Date: 04-Feb-2026
Our Ref: 2025/93370

**Application for a non-material amendment following a grant of planning permission,
Town and Country Planning Act 1990**

**Non material amendment to previous permission 2021/92062 for erection of 9
dwellings and associated works
adjacent, Britannia Road, Golcar, Huddersfield, HD3 4QB
Application Number: 2025/93370**

ISSUED TO:		PLANNING	
Project/Client:	Residential Development	Project No:	23-035
Land at Britannia Road	Golcar, HD3 4QB	Dwg No:	102
Scale:	A.S.	Rev:	C
Scale:	@A1	Drawn By:	RJ
Scale:	02/01/24	Date:	
Scale:	02/01/24	Checked By:	SC
Scale:		Date:

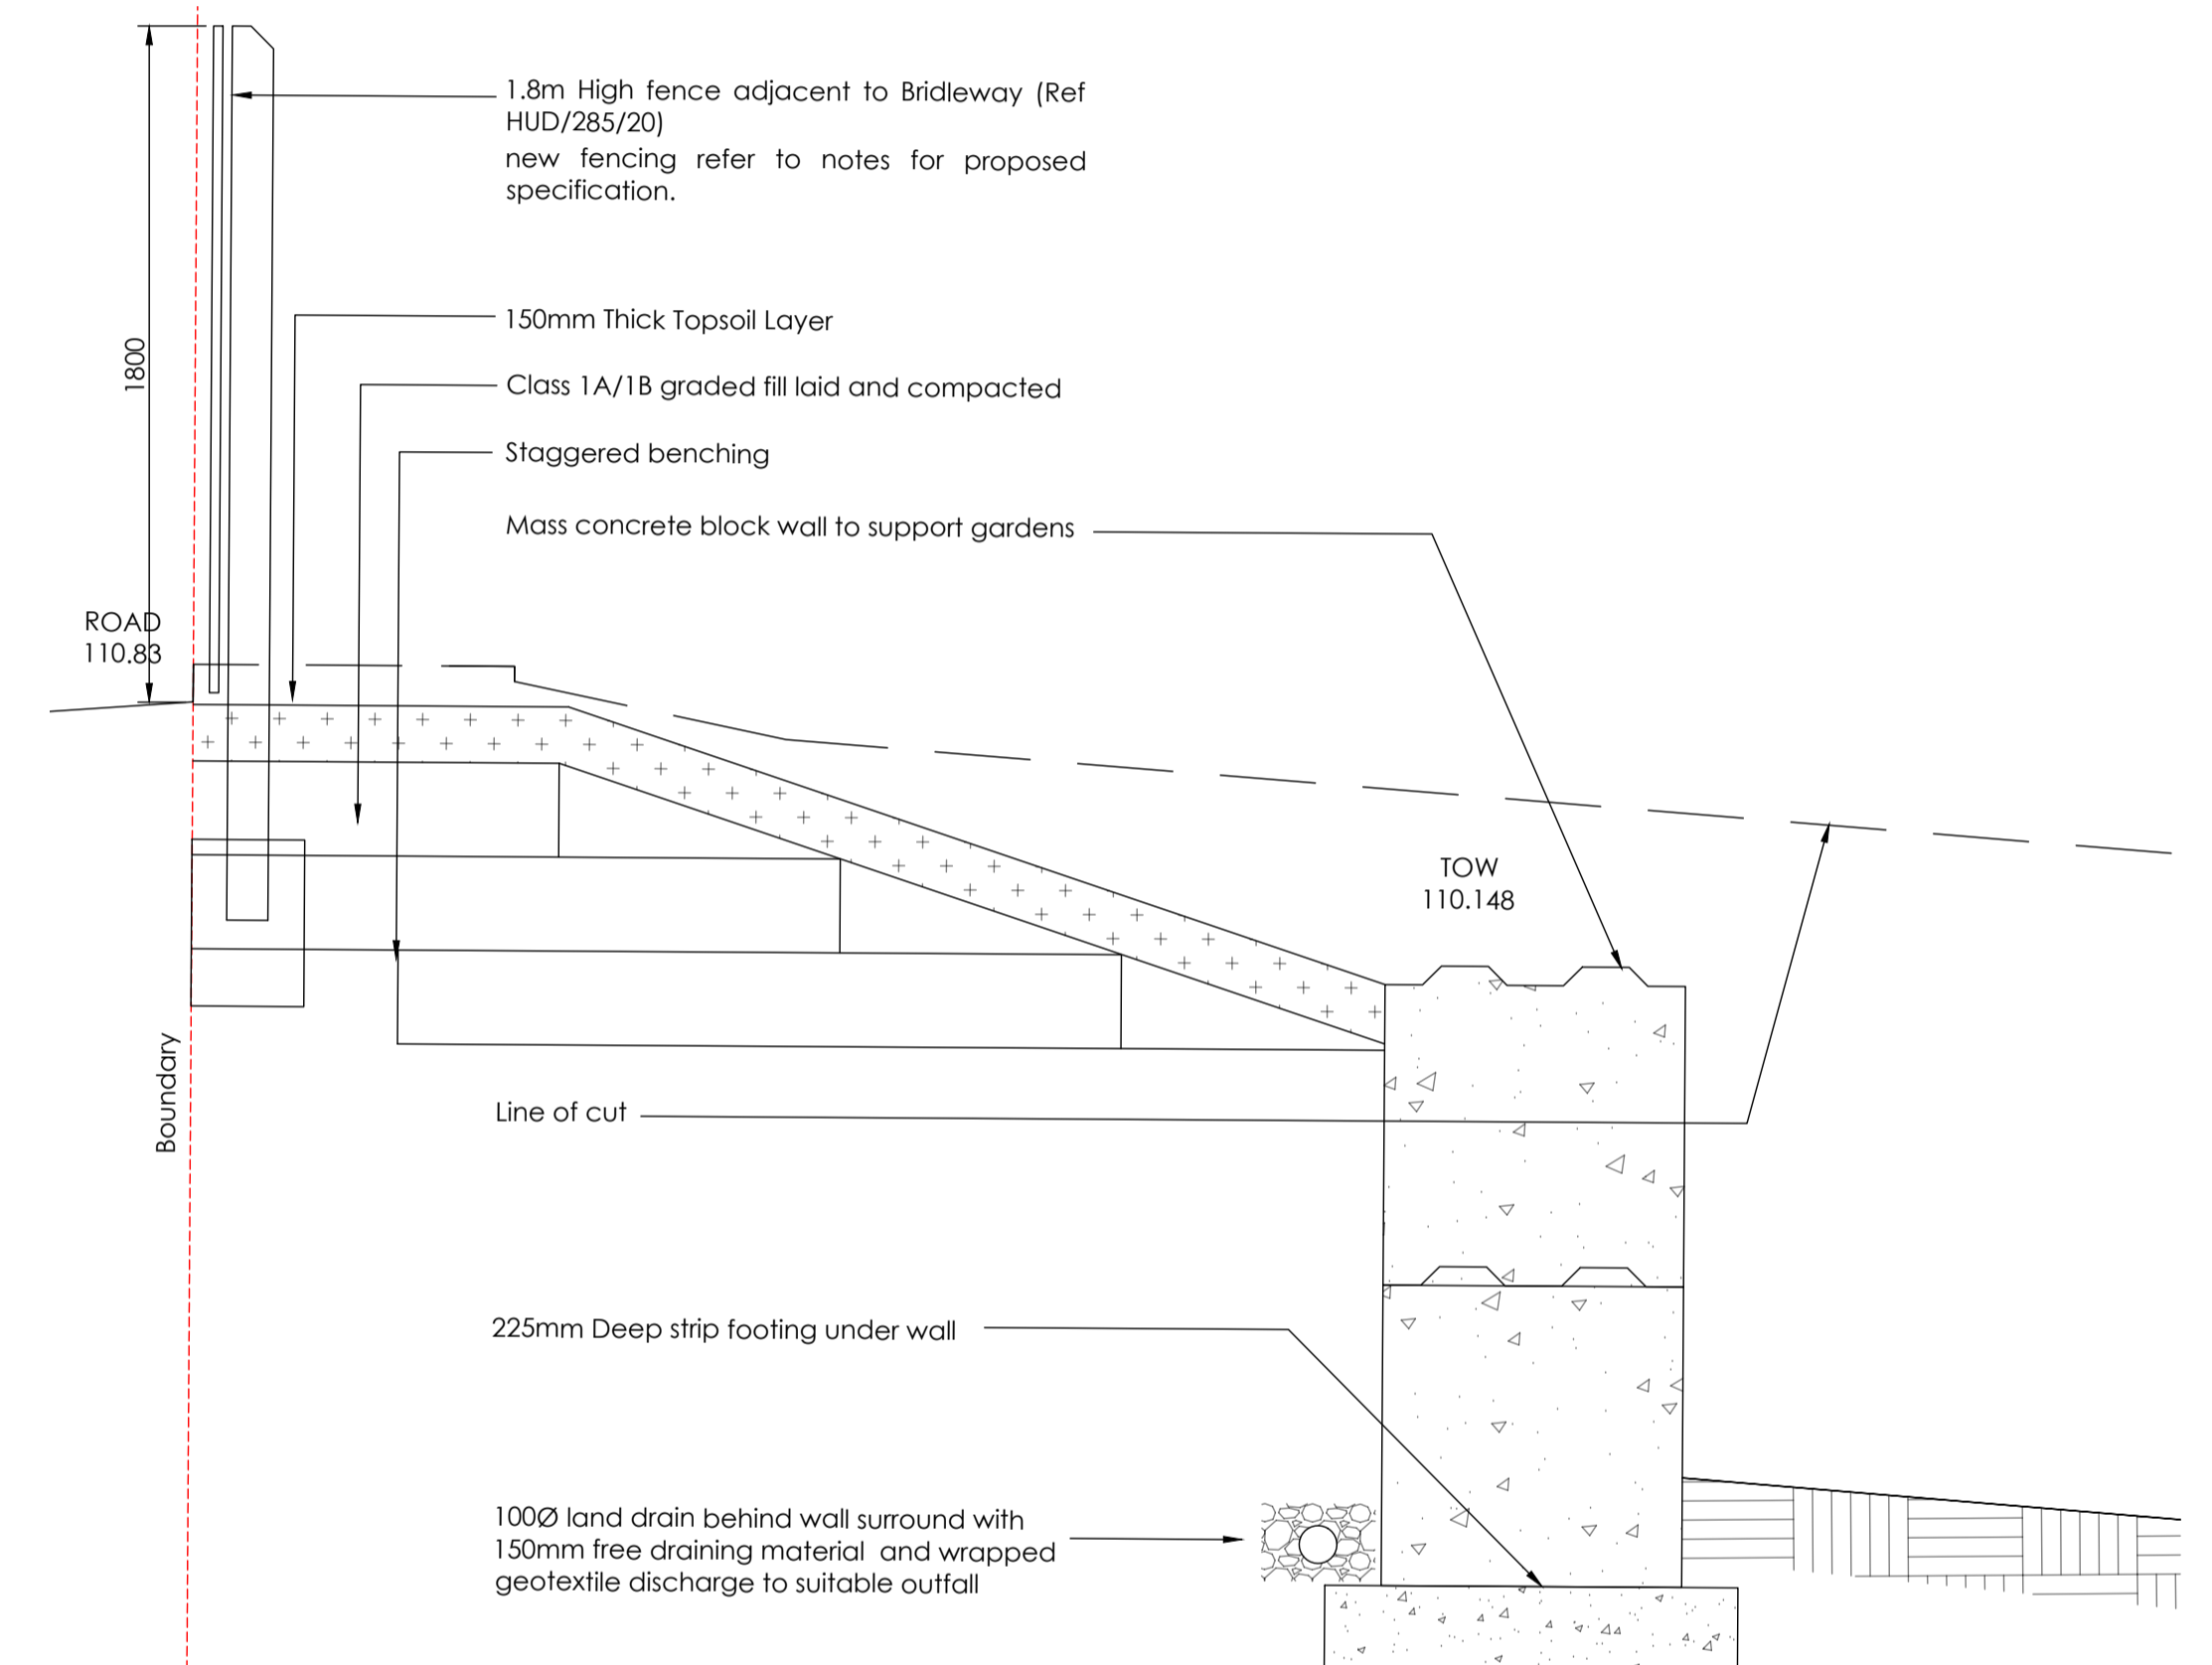
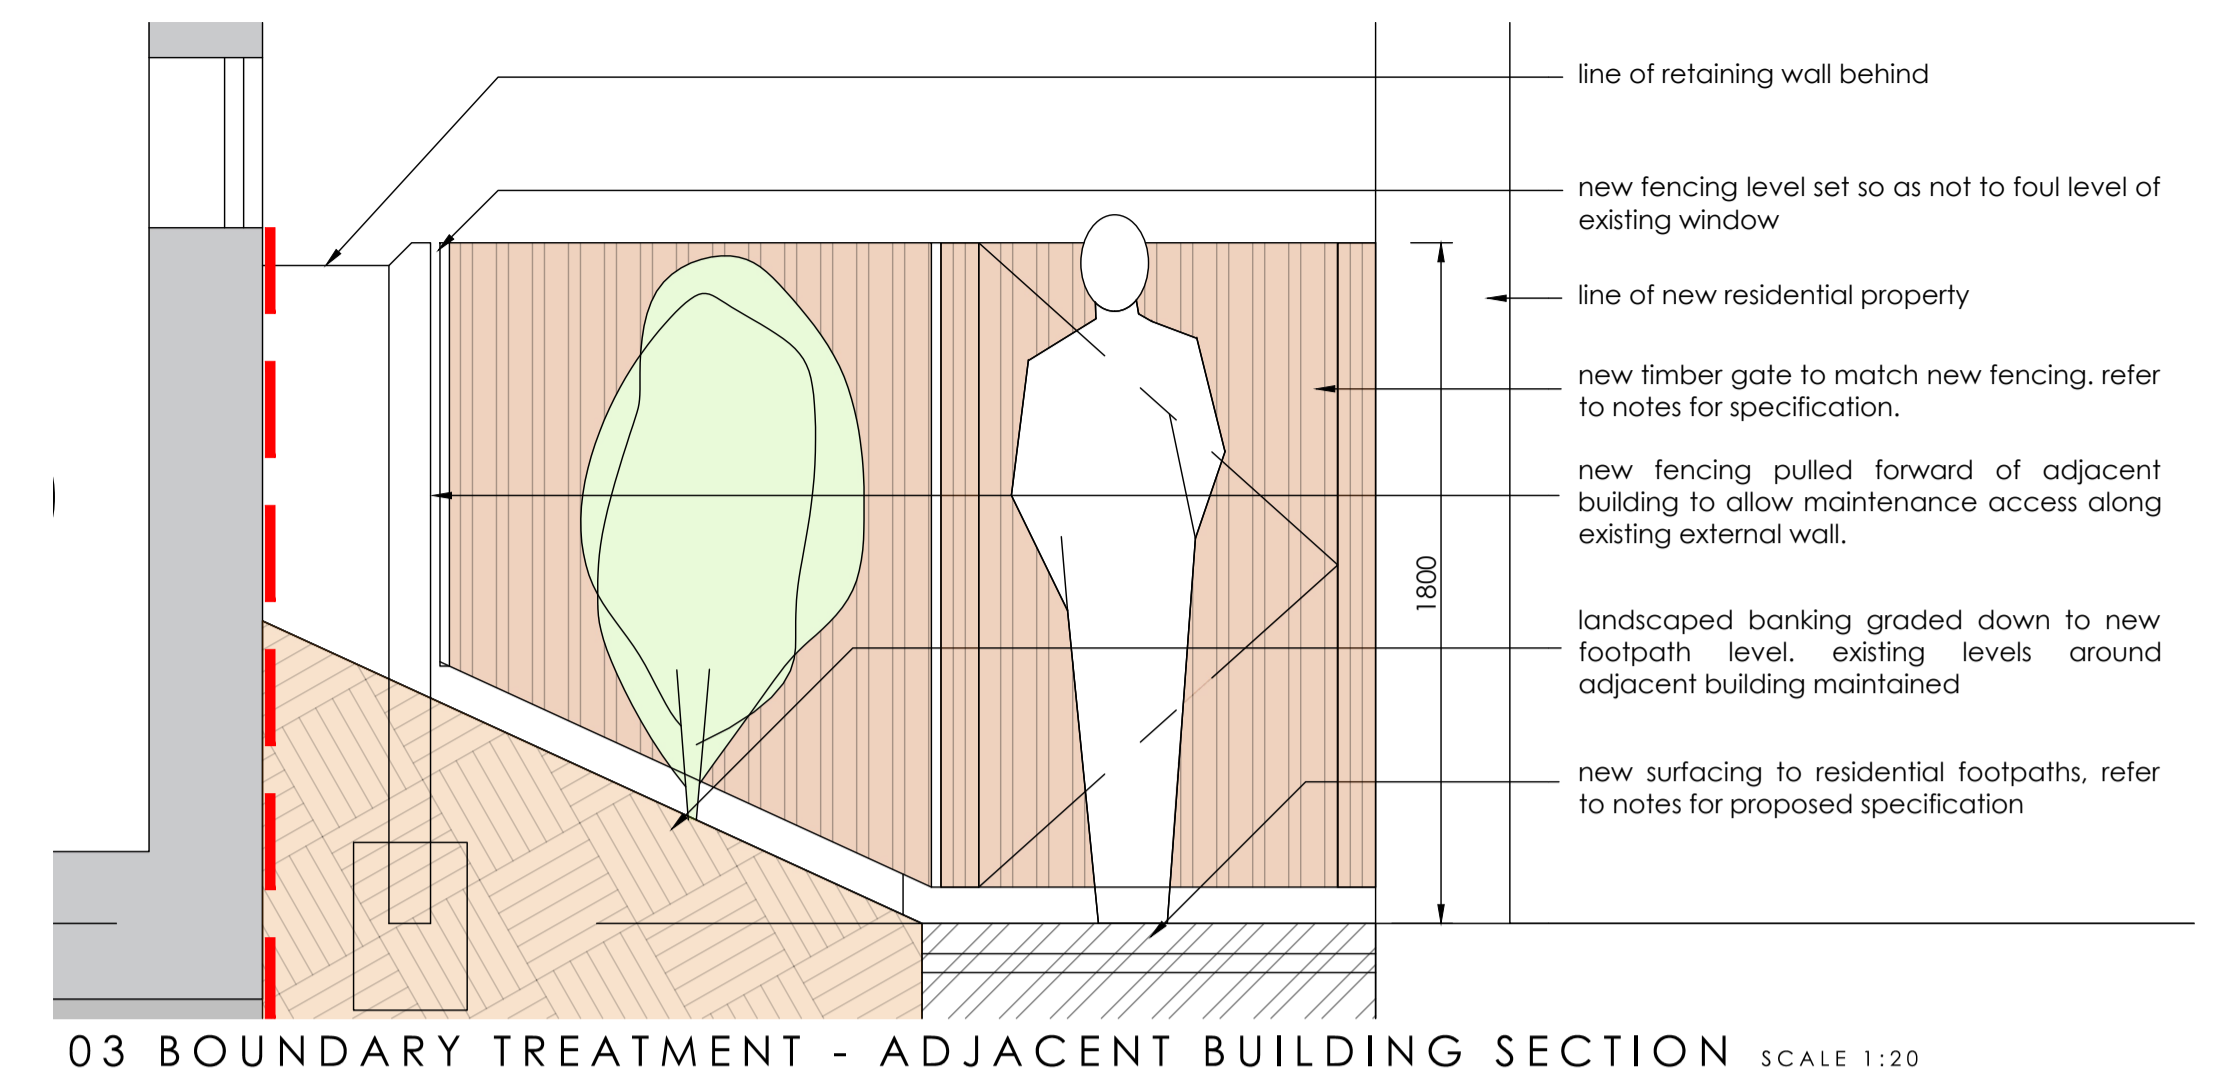
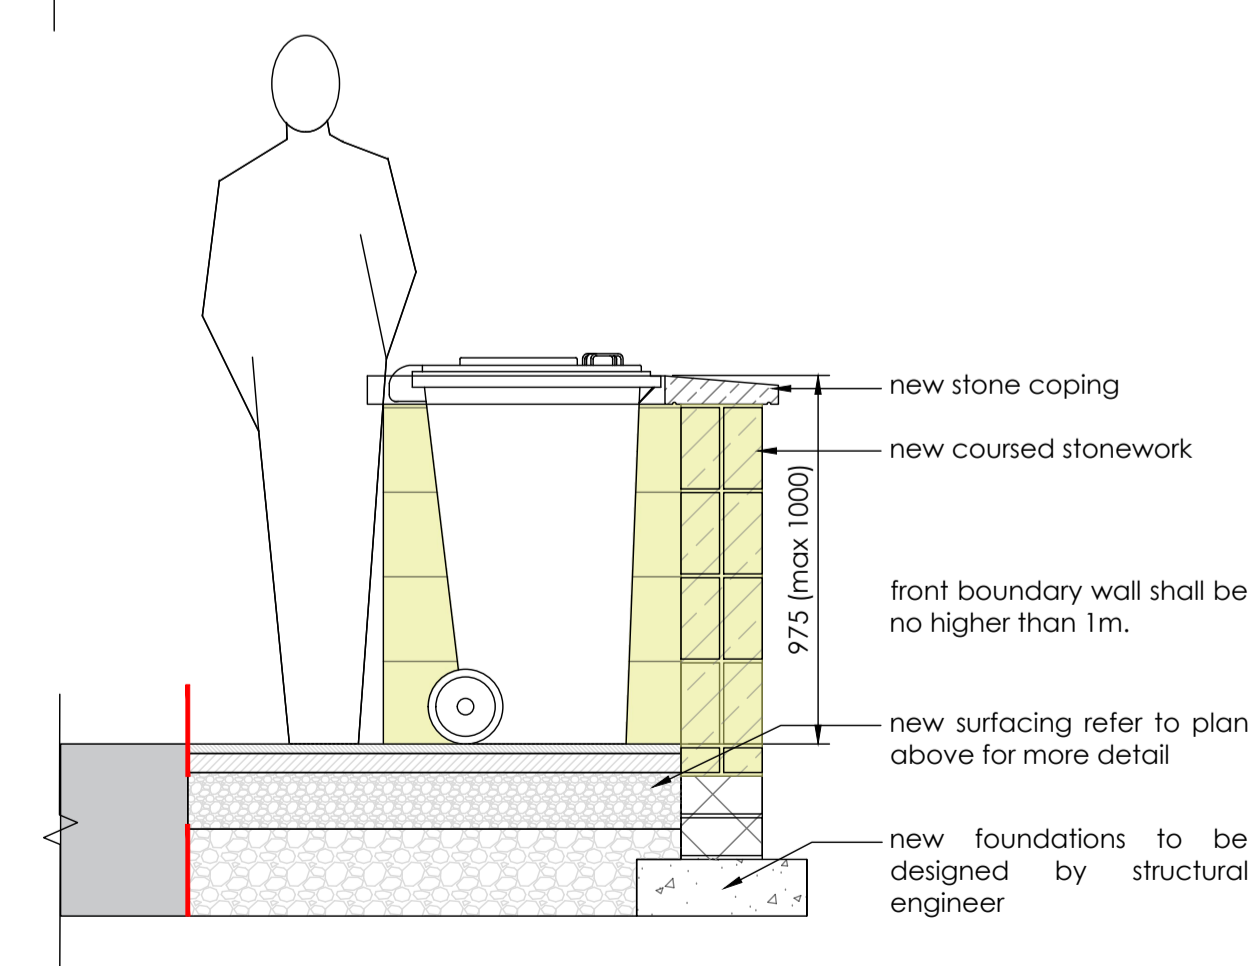
- Modifications to the previously approved retaining and boundary walls to accurately reflect the correct site levels.
- Revision of boundary walling agreed under AIP approval.

- Proposed Site Plan & Boundary Elevations, Drawing No. 100, Rev B, received 08/12/2025.
- Proposed Site Sections, Drawing No. 101, Rev B, received 08/12/2025.
- Boundary Treatment Details, Drawing No. 102, Rev C, received 08/12/2025.
- Proposed Site Location Plan, Drawing No. 106, received 08/12/2025.

14. Boundary treatment and treatment of retaining walls (i.e. facing materials) throughout the site shall be undertaken in accordance with hereby approved

drawing nos. 100, Rev B, 101, Rev B and 102 Rev C, received 08/12/2025. The front boundary wall, adjacent to Britannia Road, shall not exceed 1.0m in height. The dwellings shall not be occupied until the works comprising the approved scheme have been completed and thereafter retained for the lifetime of the development.
